Proposed Mixed Residential & Retail Development Site 2A & 3A Walker Street, Rhodes

February 2011

Prepared for **Billbergia Developments Pty Ltd**

Major Project MP 10_0105
Preferred Project Report

1 ELEVATION
Walker Street Elevation
1 : 350

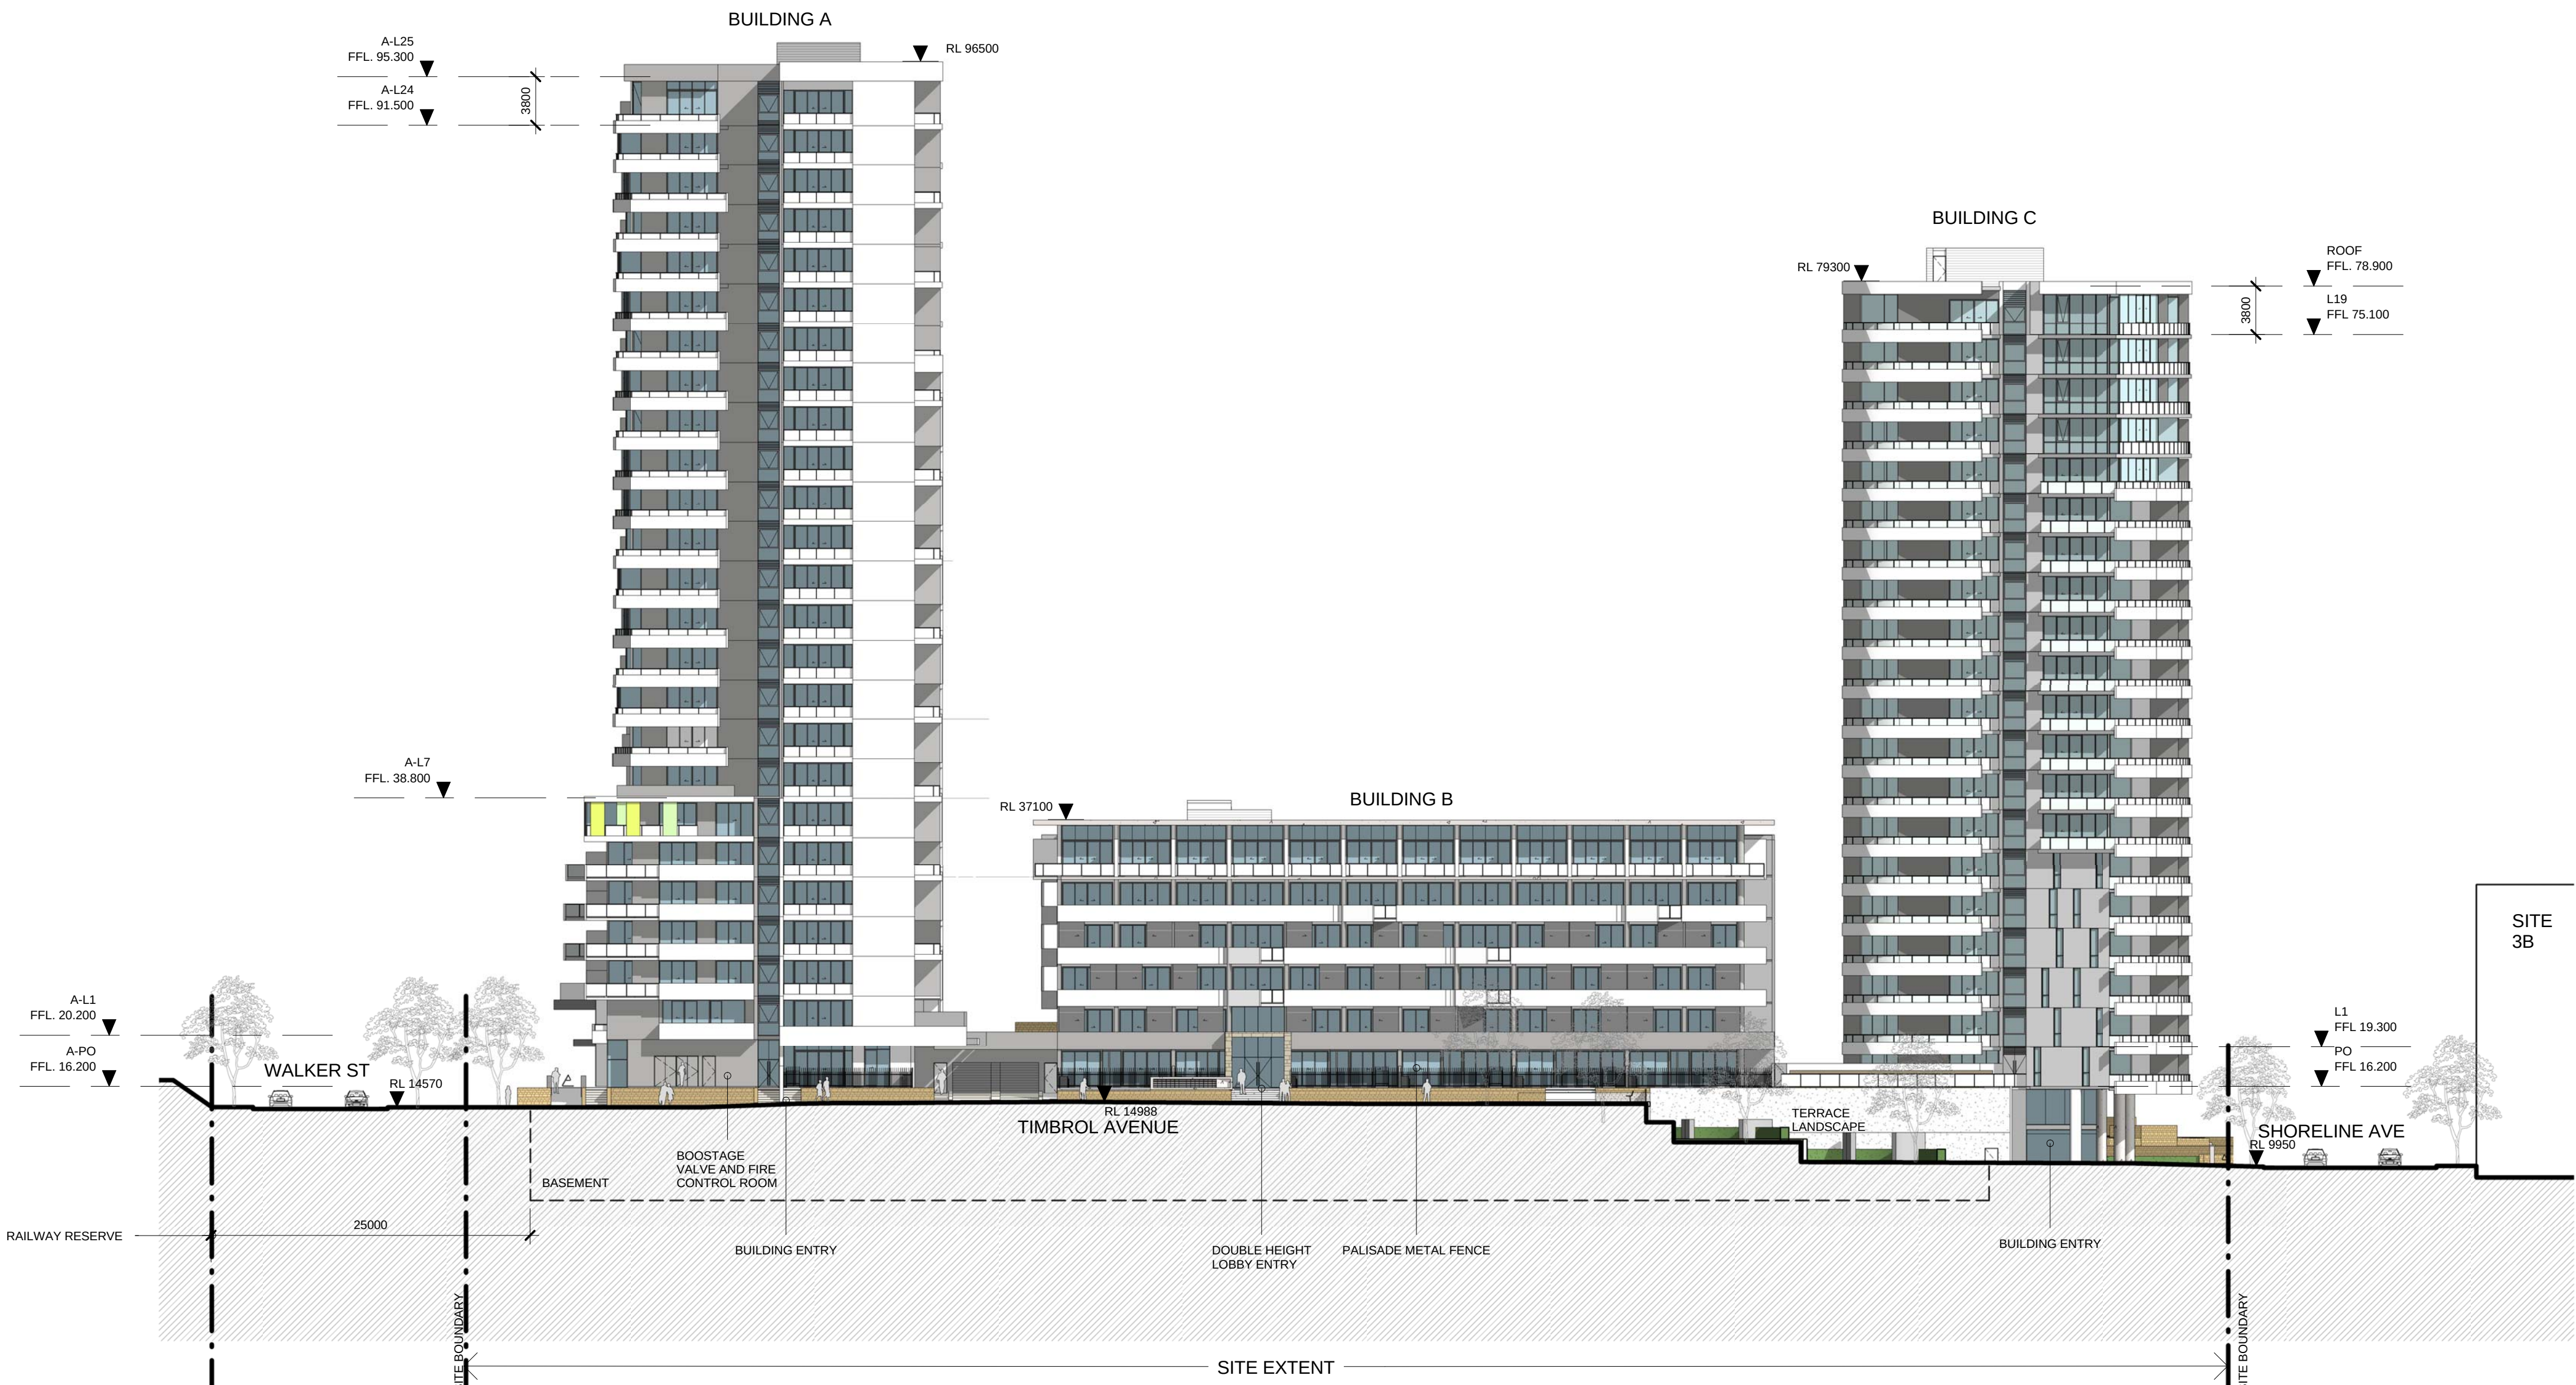
“The provision of a setback on this corner would clearly provide a more appealing streetscape, particularly in view of the surrounding buildings being effectively built up to the footpath. This would also assist in addressing privacy issues for all of the existing corner apartment sin the building on the other side of Timbrol Avenue”.

In relation to the DCP requirement for a small plaza on the corner of Timbrol Avenue and Walker Street, consultation with GMU since the end of the exhibition period, has confirmed the necessary amendments to be made for this Preferred Project Report. GMU have requested that Building A be moved between 1 metre and 1.5 metres forward to Walker Street. This amendment is required to reinforce the DCP ‘streetwall’ to Walker Street.

The setback to the corner of Timbrol Avenue is identified as a non-compliance by Council’s urban design consultant GMU Architects and Urban Designers. GMU states that the proposed setbacks to Timbrol Avenue are acceptable for the following reason:

It is therefore considered that because the adequate separation distances is provides that visual privacy will be within an acceptable for opposing buildings fronting Timbrol Avenue.
